DRB Application No.: 05DRB-00824 (P&F)

Project Name: TIJERAS PLACE ADDITION

**CITY OF ALBUQUERQUE
PLANNING DEPARTMENT
May 25, 2005
DRB Comments**

RE: Tijeras Place Addition/minor P&F plat

**PLAT OF**  
**TRACTS A-1, A-2 & A-3, BLOCK 13**  
**TIJERAS PLACE ADDITION**  
 SECTION 24, T. 10 N., R. 3 E., N.M.P.M.  
 CITY OF ALBUQUERQUE  
 BERNALILLO COUNTY, NEW MEXICO  
 MAY 2005

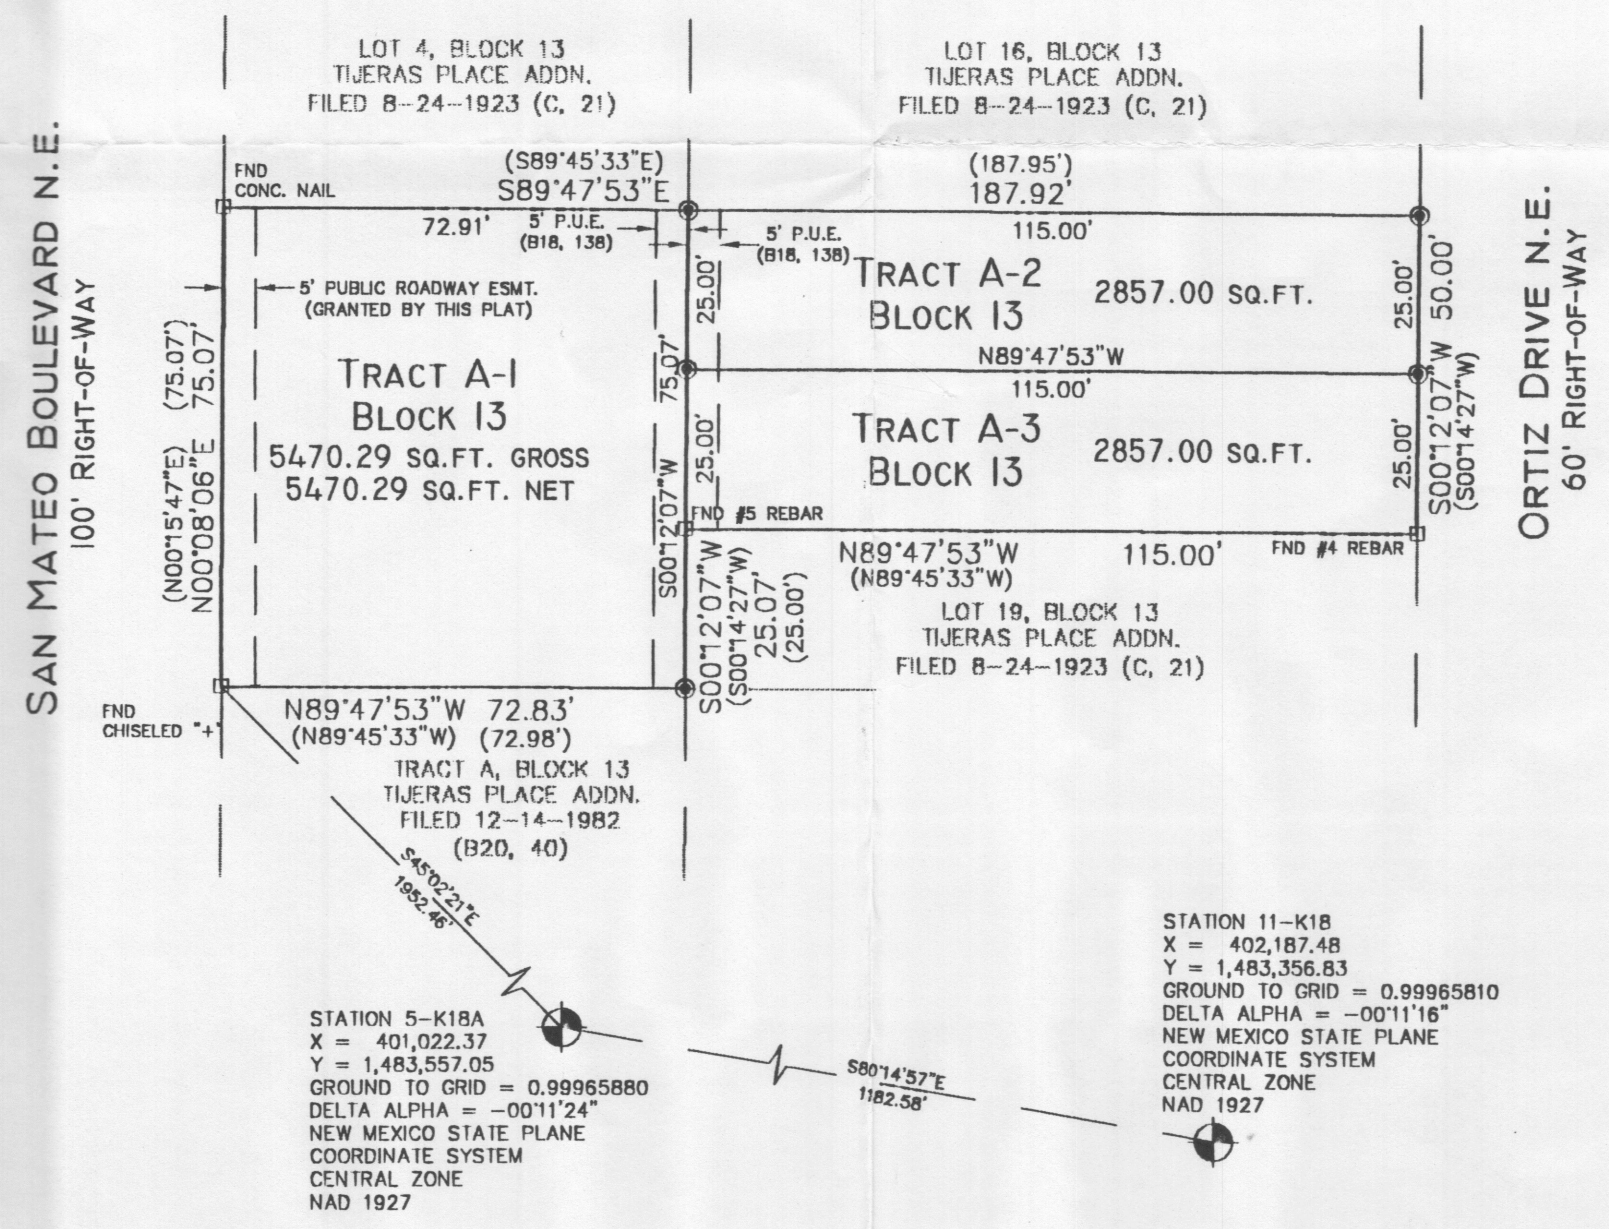
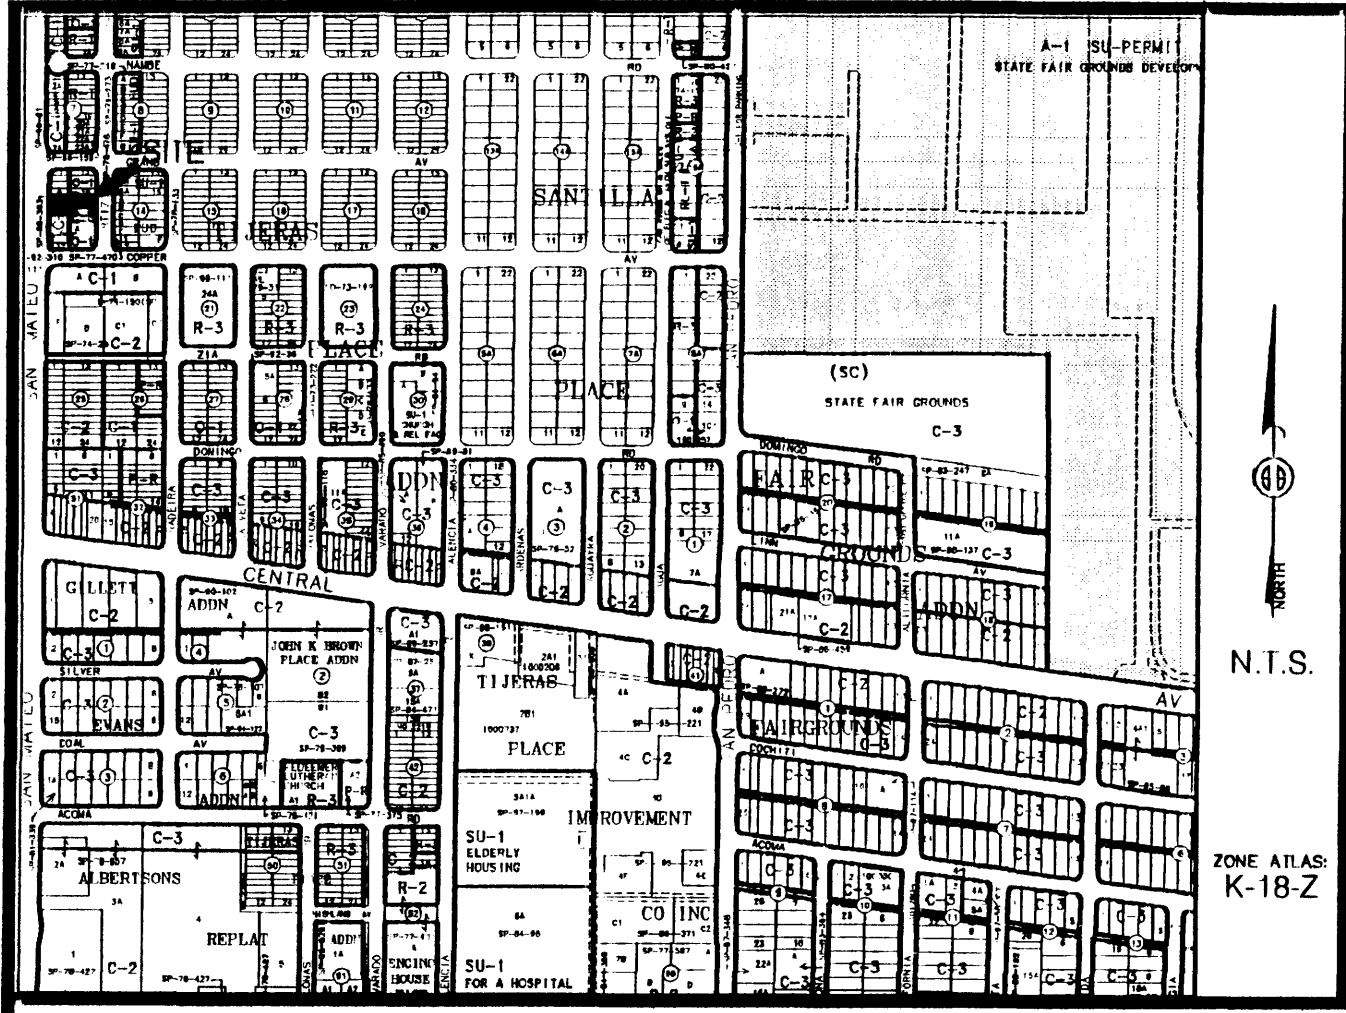
TRANSPORTATION: TRACT A-1 4' ROADWAY easement

SURVEYS SOUTHWEST LTD agent(s) for TOM WELCH request(s) the above action(s) for all or a portion of Tract(s) A, Block(s) 13, **TIJERAS PLACE ADDITION**, zoned C-1 & O-1, located on SAN MATEO BLVD NE, between COPPER AVE NE and ORTIZ DR NE containing approximately 1 acre(s). [REF: 04ZHE01621] (K-18) **PRELIMINARY PLAT WAS APPROVED WITH FINAL SIGN OFF DELEGATED TO TRANSPORTATION DEVELOPMENT FOR A 4 FOOT RIGHT-OF-WAY EASEMENT ALONG TRACT A-1.**
